EP-22-0031\_1 Ohana Acres  
NW¼ NW¼ Section 30 T13S, R63W, 6th P.M.  
38.8943, -104.4967

Colorado Geological Survey comments uploaded to El Paso County Development Application Review on 9/12/2022:

With this referral, CGS received the Final Plat (Compass Surveying & Mapping, LLC, January 25, 2019), Letter of Intent (G & D Hammann Ohana Trust, September 30, 2021), and Geology and Soils Reports (Allison Engineering, October 28, 2021). We understand that the 19.31-acre site will be subdivided into four lots. Lot 1 includes an existing home, and lots 2 through 4 will consist of future structures and individual well and septic systems.

FINAL PLAT OHANA ACRES

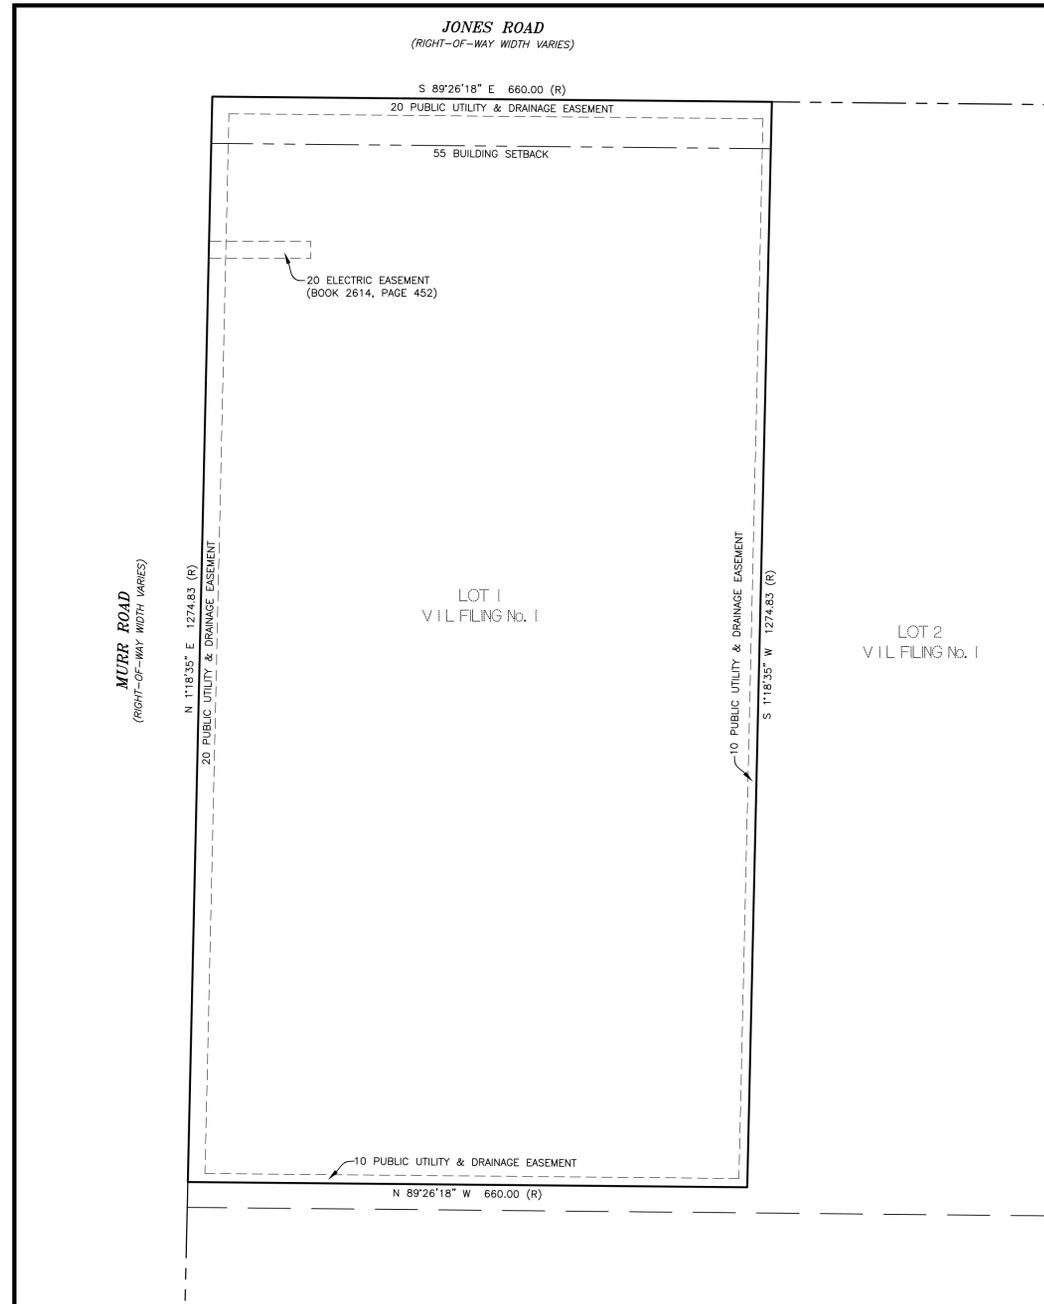
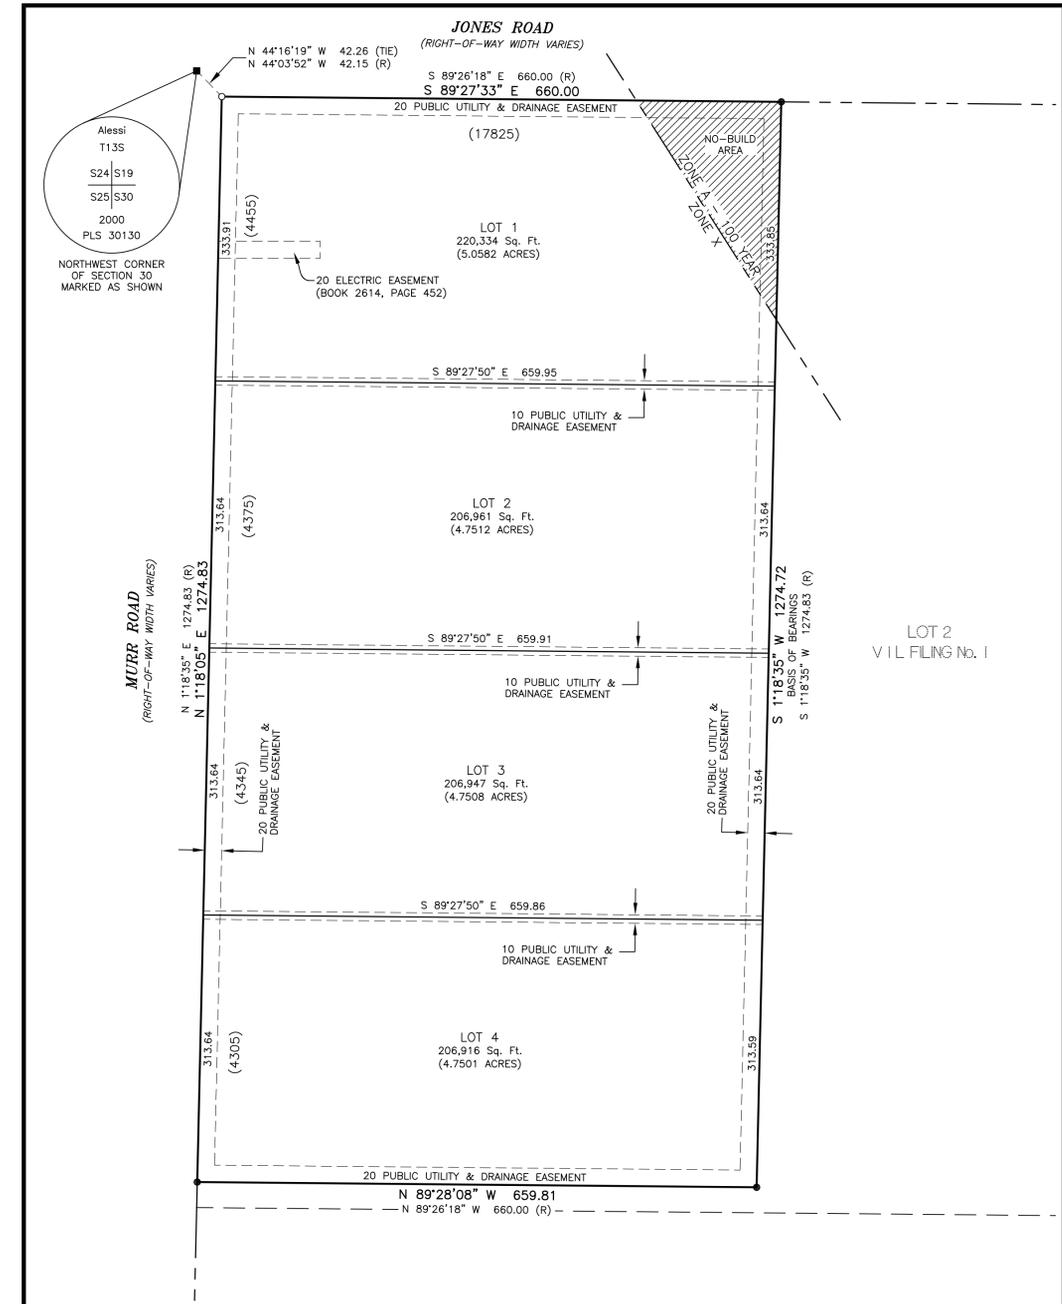
1. The subsurface conditions described in Allison Engineering's report are based on the results of six excavations; however, no test pit logs or laboratory testing results were provided. Allison Engineering (page 3) describes the soil as “sand to loamy sand per the U.S. Department of Agriculture Soil Classification System.” Without the field investigation results, CGS cannot come to the same conclusions and identification of geologic hazards and constraints as Allison Engineering. CGS recommends that the county require the soil and geology study to be expanded to evaluate the geologic constraints based on a site-specific investigation and data. **A note should be included on the final plat listing the geologic hazards and constraints with appropriate mitigation measures.**

2. Also, Allison Engineering states (page 8) that “It is expected the program of subsurface exploration and testing necessary to satisfactorily determin (sic) site-specific subsurface conditions can be accomplished with a backhoe. The use of a (sic) exploratory drill will likely extend to a depth not useful for foundation or septic system design.” If basements are planned for future structures, test borings drilled to a sufficient depth (generally at least 20 feet) are necessary to determine groundwater and bedrock depths where both are likely to be shallow. If shallow groundwater is encountered or expected based on the subsurface conditions, the report should discuss the seasonal groundwater fluctuation expected at the site based on site-specific data. **The feasibility of basements or other anticipated habitable below-grade space should be discussed and noted on the plat.**

3. Allison Engineering states (page 8), “Cuts and test holes needed for additional geologic information would be needed to determine consistency with the findings of this study and to comply with the requirements of the El Paso County Health Department.” **CGS recommends that a note be added**

**to the final plat requiring lot-specific geotechnical and septic investigations once building locations have been determined.** The lot-specific geotechnical and septic investigations will be needed to:

- Determine the thickness and extent to which the soils beneath each proposed structures are subject to collapse under loading and/or wetting; characterize soil and bedrock engineering properties such as density, strength, water content, swell/consolidation potential, and bearing capacity; determine depths to groundwater, bedrock, and any impermeable layers that might lead to the development of a perched water condition.
- Determine percolation rates for each lot to determine if engineered septic systems are necessary.
- Provide earthwork, foundation, floor system, subsurface drainage, and pavement recommendations for design purposes.
